Tween Bridge Solar Farm

9.10 Statement of Common Ground with National Highways

Deadline 3 June 2026

Statement of Common Ground

Document Ref: 6.4.6.4 AFPP Reg: 5(2)(a) Revision: 2
 PINS Number: EN010148 Drawing Status: Final
 Drawn: LAB Checked: HS Approved: KC Date: 17/04/2026

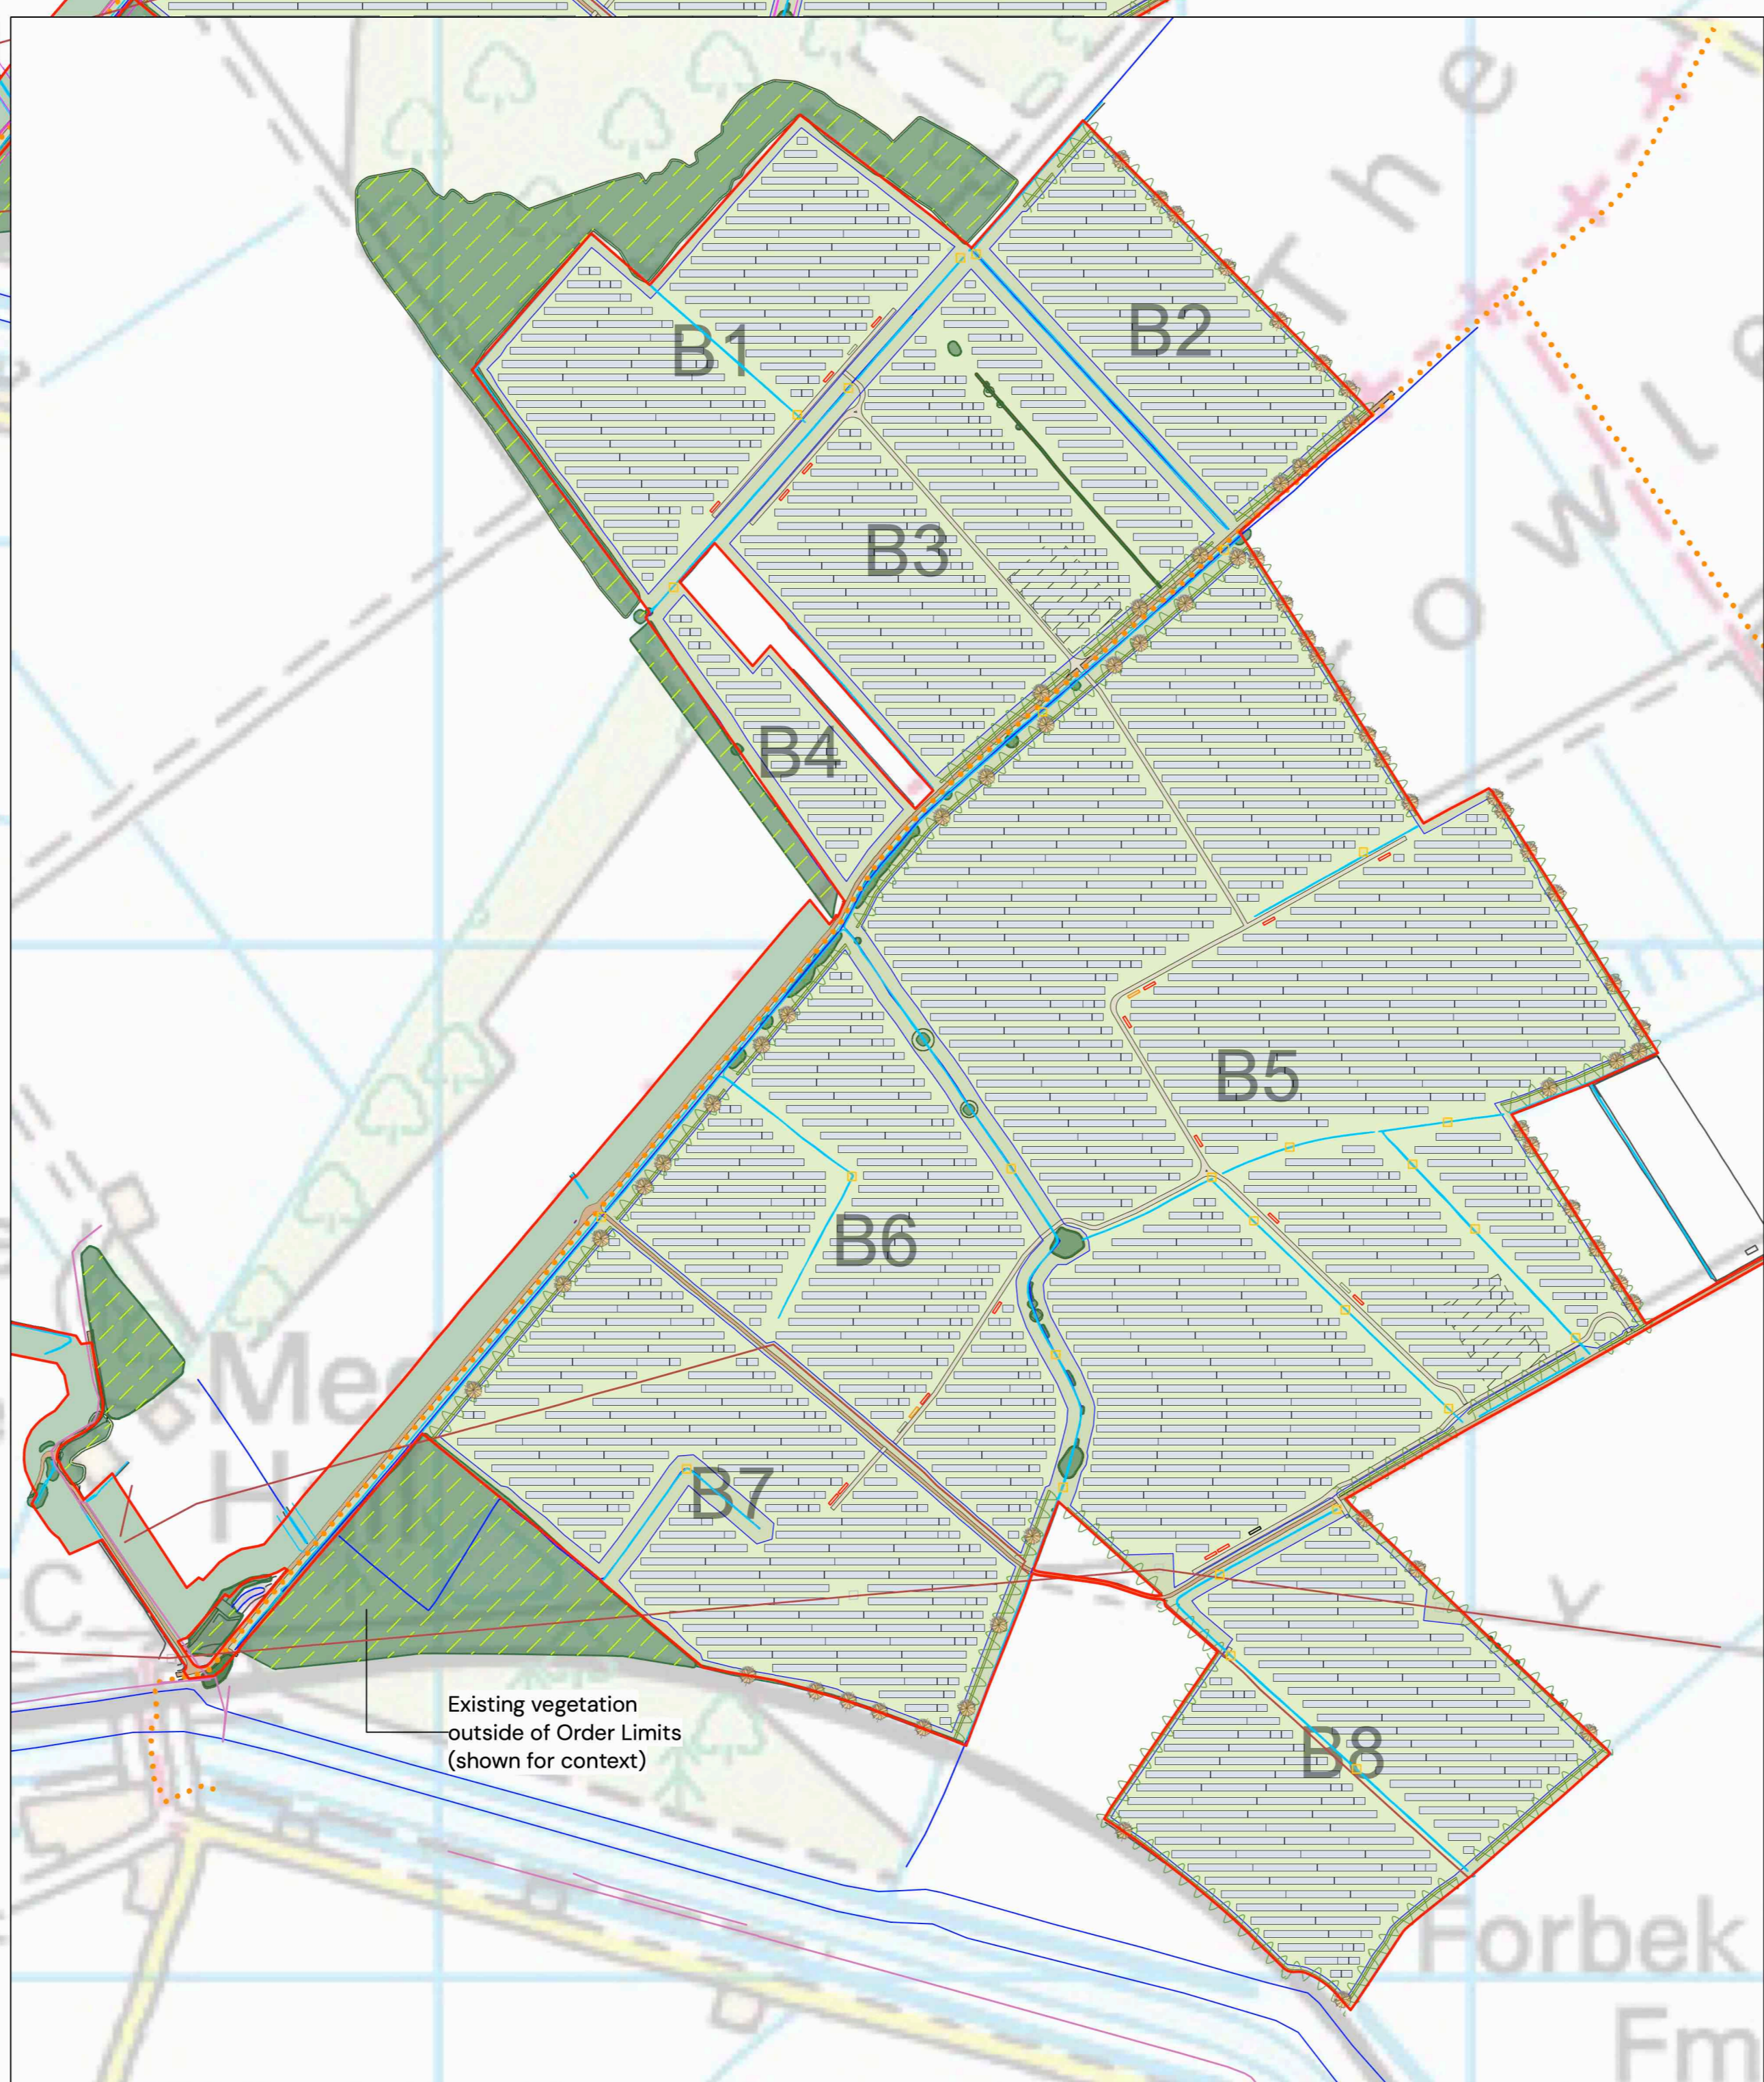
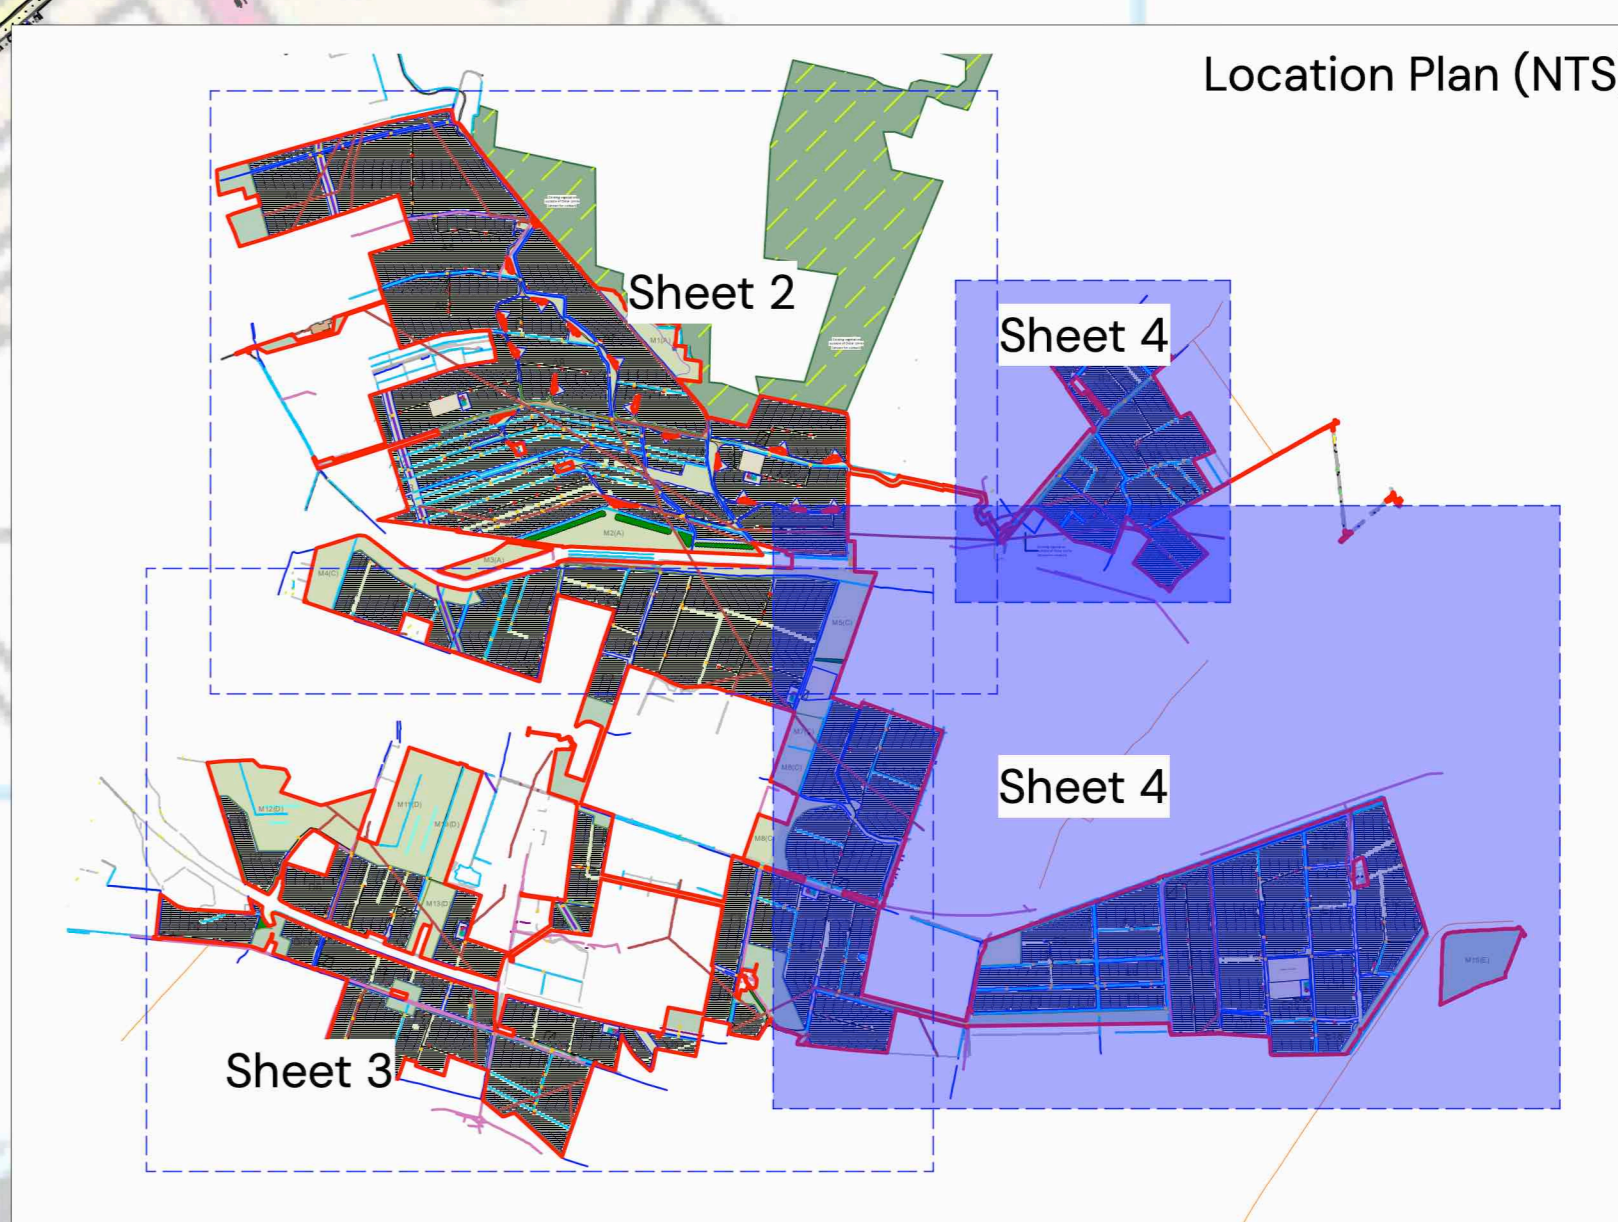
7	Glint and Glare Assessments [APP-122 and REP1-025] and Outline	NH notes that no dedicated mitigation is proposed in respect of glint and glare effects. The residual effects of glint and glare can have substantial impact on the	In the Glint and Glare assessments, mitigation is only required where a high impact is predicted on a road. Environmental Statement	Under discussion

<p>Landscape Ecological Management Plan [REP1-034]</p>	<p>safety of road users and it is of critical importance to NH that the mitigation applied in the Landscape Ecological Management Plan is satisfactory and suitably maintained to enable establishment.</p> <p>The Applicant is also proposing additional planting in existing planting areas in close proximity to the SRN, which would require the approval of NH's environmental team due to the sensitive ecosystem at these locations.</p> <p>NH therefore requires that Requirement 8 of the draft DCO is amended to include NH as an approving body for the detailed Landscape Ecological Management Plan with regard to the specific elements relevant to the SRN (refer to point 9 below).</p>	<p>Appendices 16.1 and 16.2 [REP1-025 and REP1-026] conclude that a moderate impact is predicted on separate 0.2km and 1.6km sections of the M180, and a 0.1km section of the A18. On the basis that the predicted impact is moderate, mitigation is not deemed to be required. However, planting has nonetheless been proposed as part of the Scheme to reduce the effect further over time.</p> <p>The Applicant agrees that appropriate provision must be made for the ongoing management and maintenance of planting. The proposed management prescriptions for retained and proposed planting are set out in Table 4-1 of the Outline Landscape Ecological Management Plan [CR1-021] submitted at Deadline 1.</p> <p>The location of the proposed mitigation planting to screen views of the fencing and panels and in turn to mitigate glint and glare effects are set out on the drawings at ES Figure 6.4 Landscape and Visual Mitigation Strategy [Document Reference 6.4.6.4 Revision 4]</p>

<p>submitted at Deadline 1. A Landscape and Ecology Plan submitted for approval under Requirement 8 of the draft DCO [Document Reference 3.1 Revision 6] must be substantially in accordance with the Landscape and Visual Mitigation Strategy, therefore ensuring the proposed mitigation is legally secured.</p> <p>The Applicant considers that the relevant local planning authority is the appropriate consent granting body in respect of the written Landscape and Ecology Management Plan submitted under Requirement 8.</p> <p>However, the Applicant amended the draft Development Consent Order (DCO) at Deadline 1 [REPI-004] to include a requirement to consult National Highways in relation to a written Landscape and Ecology Management Plan submitted for approval (insofar as the plan makes provision for matters which relate to NH's functions).</p> <p>The Applicant considers that this approach is sufficient and appropriate in the circumstances,</p>
